From: Jordan Bovee <jordan.bovee.hsy@colvilletribes.com>
Sent: Tuesday, December 16, 2025 10:46 AM
To: Bradley Gasawski
Subject: Re: SP-25-00012 Clear View - Notice of Application

This review is in response to the request for comment on the SP-25-00012 Clear View short plat application.

HORIZONTAL CONTROL,
GRADING & DRAINAGE PLAN

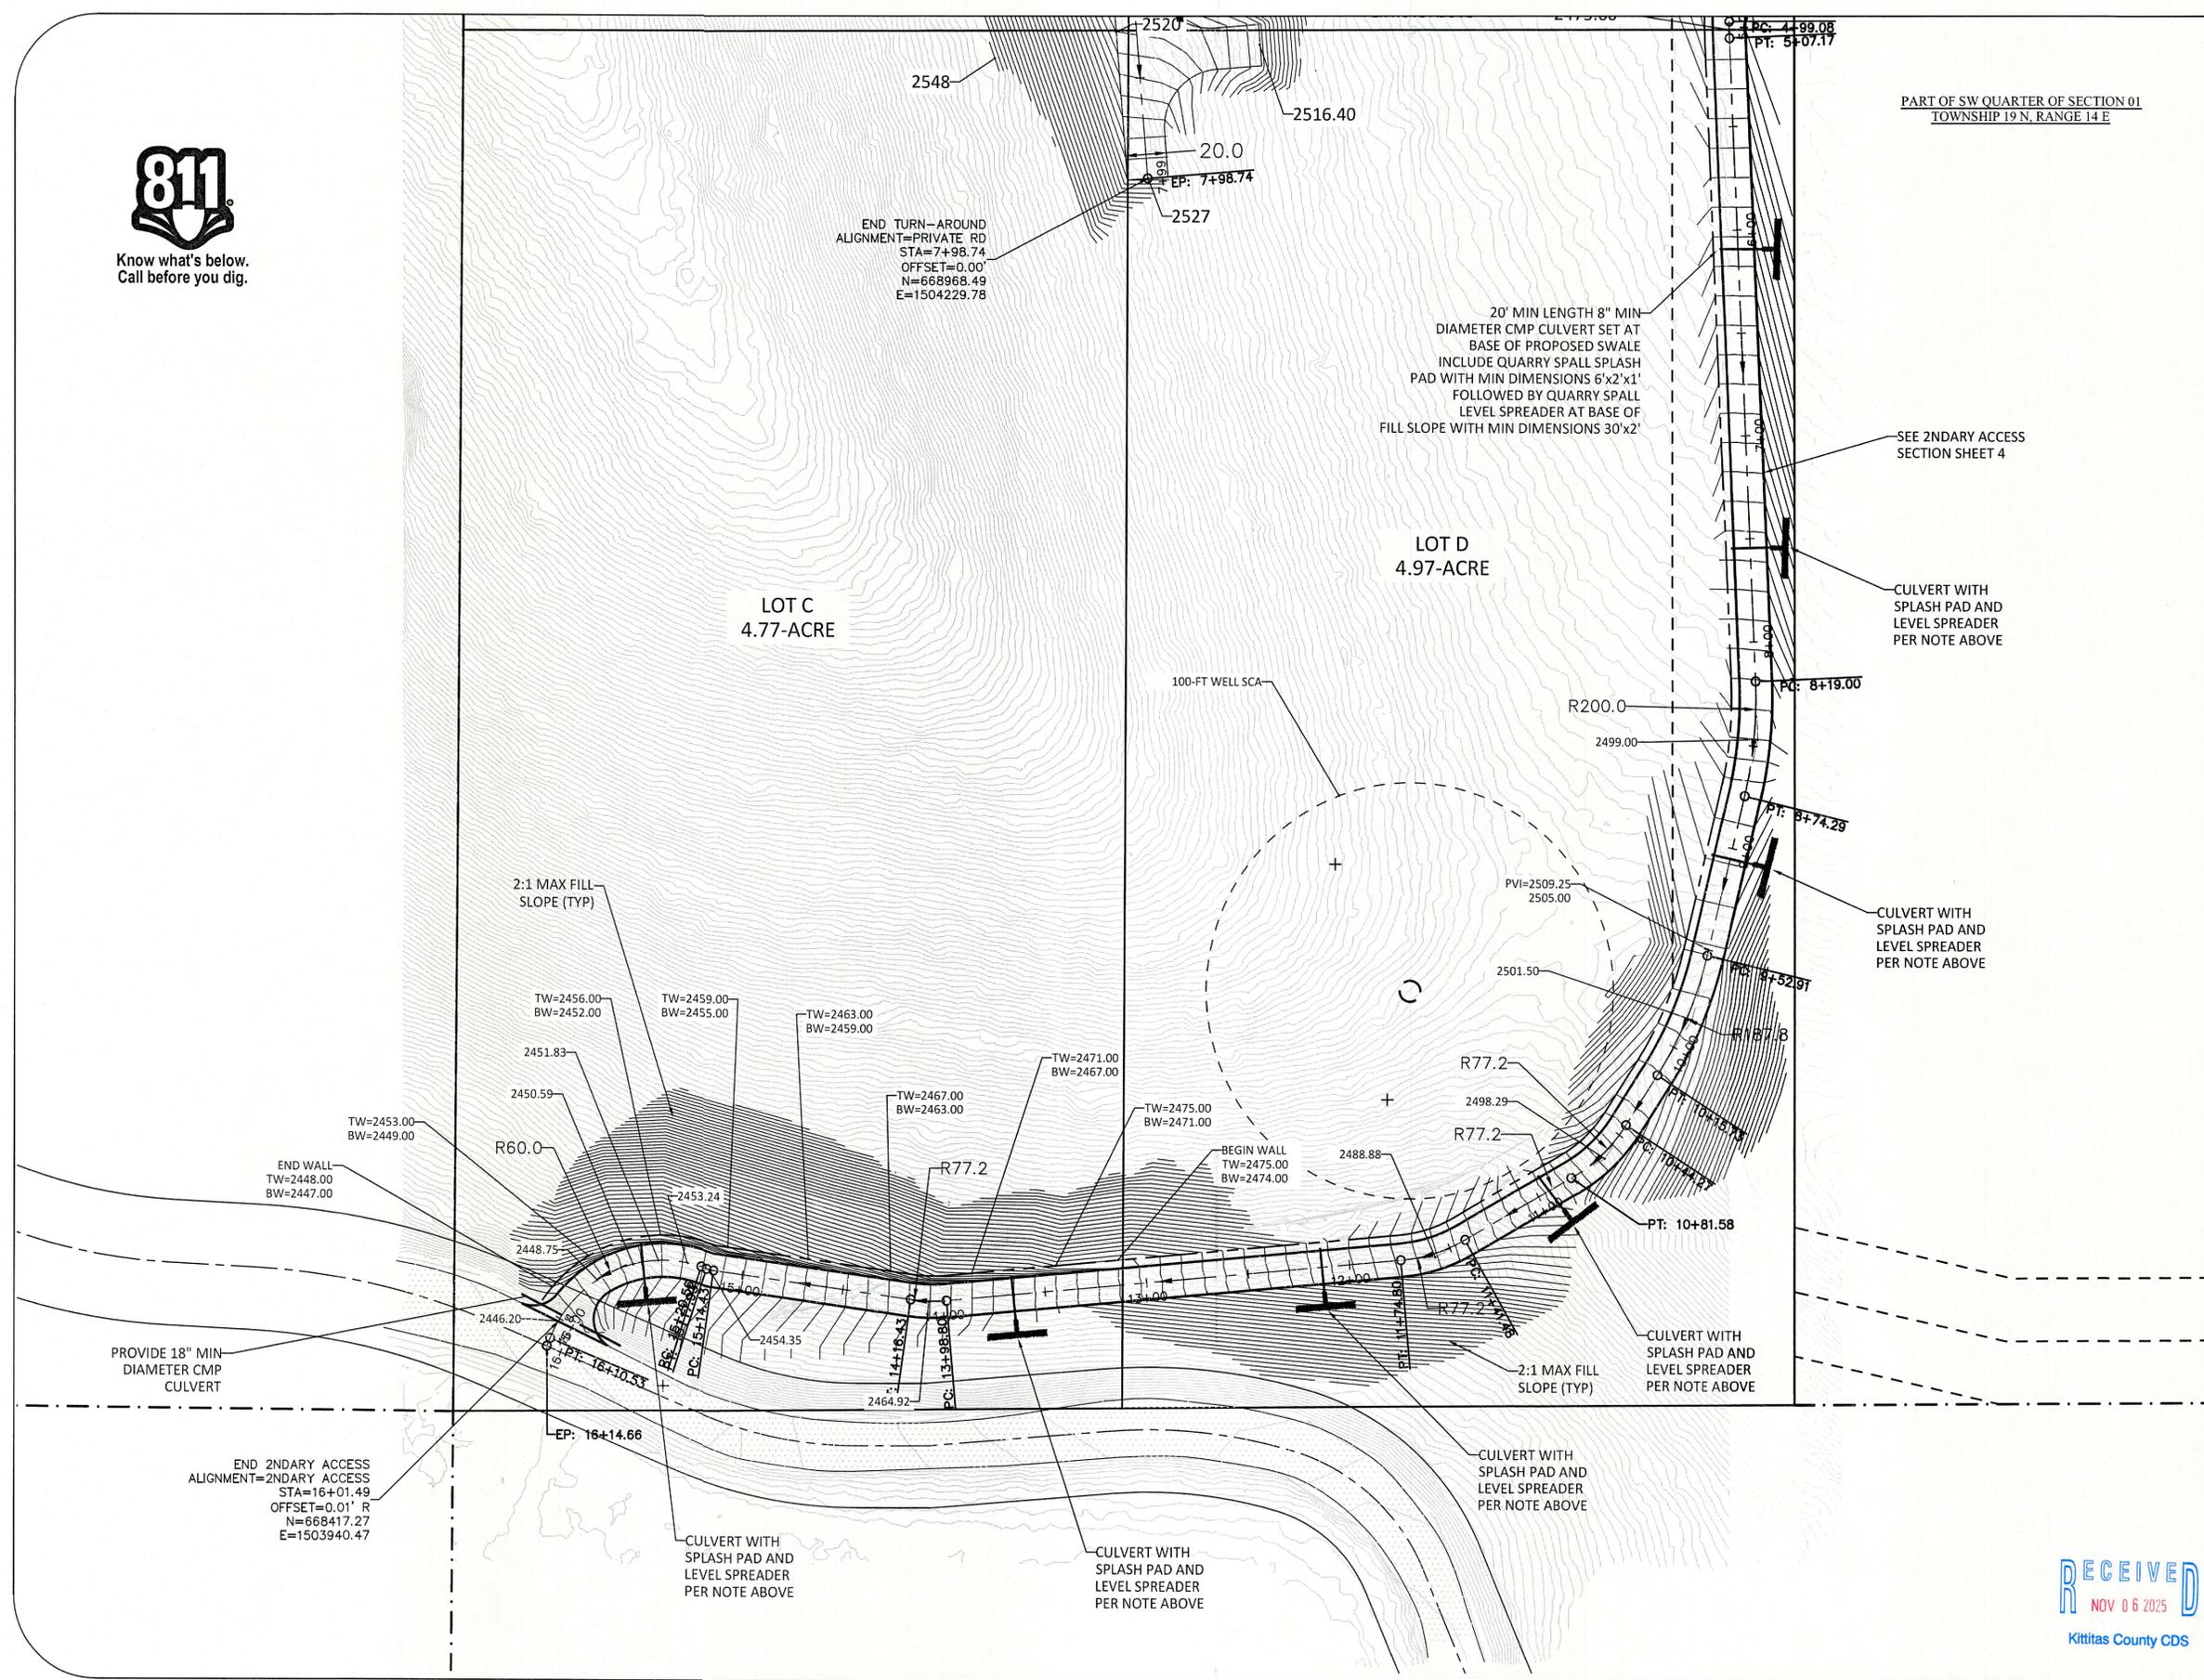
DAHP's predictive model suggests this area is at moderate risk for cultural resources to be present, and advises survey. Given the proposed access improvements to the plat which include grading and the placing of culverts and impermeable surfaces (roads), as well as in the interest of streamlining future development efforts on these lots, we would concur and recommend that a full cultural resource survey with an appropriate subsurface testing schema be carried out ahead of project implementation. We would also request a copy of any report produced as a result of such an effort. An Inadvertent Discovery Plan would also be very appropriate for the ground disturbing work proposed.
